Biofuelwatch comments relating to Rule 17 Questions of 6 June 2023 (R17QA)

The Rule 17 Questions of 6 June 2023 (R17QA) asked Biofuelwatch "if it is able to provide evidence to support its view that there are a range of meteorological conditions likely to exist under which less-than-maximum ground level impacts could combine to exceed the maximum ground level impact for one plant?"

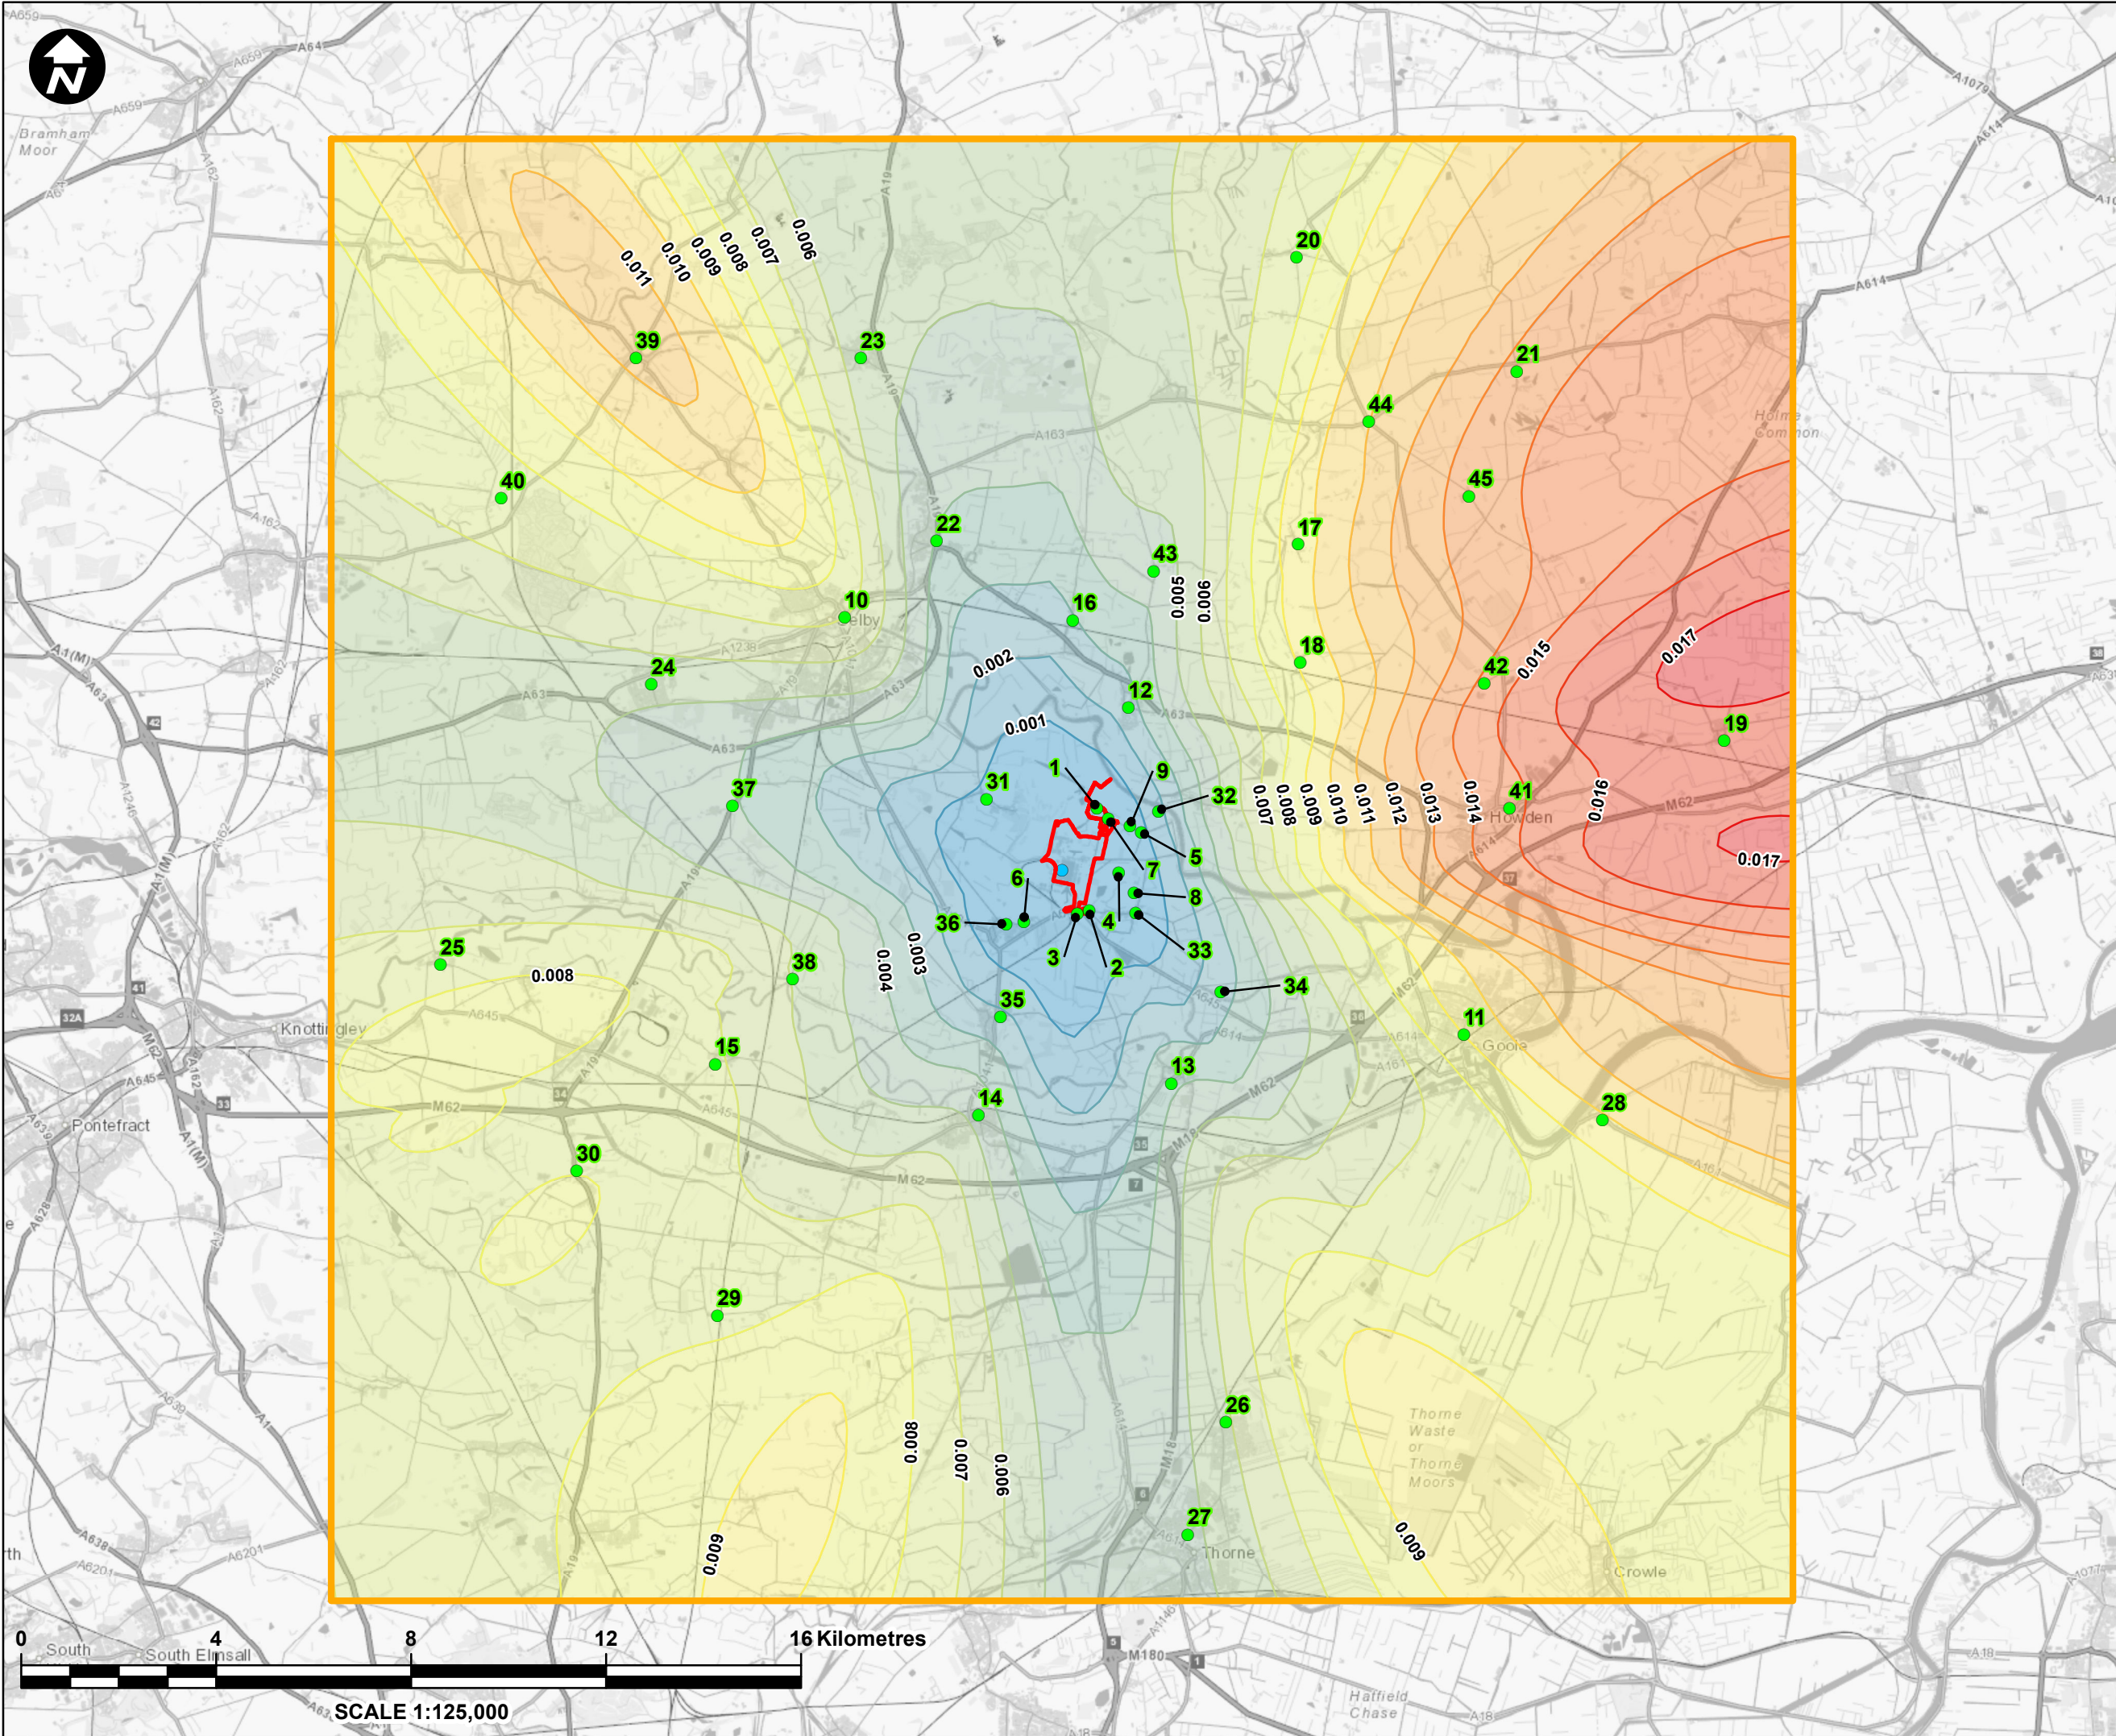
Consider what would happen to Drax's emissions if the wind direction is towards Keadby 3. Drax's plume often results in elevated ground level concentrations at the distance that Keadby 3 is from Drax (the figures in the Environmental Statement, such as Figure 6.8, predicts Drax's nitrosamine concentrations). Drax's plume would spread in width over the distance to Kaedby 3 and Drax's ground level nitrosamine pollution would be expected to

typically extend for a considerable distance downwind (more on this further down). This spread in the plume, both in width and distance, means that there will be a range of meteorological conditions that would result in elevated pollution levels from Drax in the vicinity of Keadby 3. The width of the plume means the wind direction does not have to be precisely in the direction of Keadby 3 from Drax for there to be elevated levels near Keadby 3. Elevated levels from Drax will also occur for a range of wind speeds, temperatures etc.
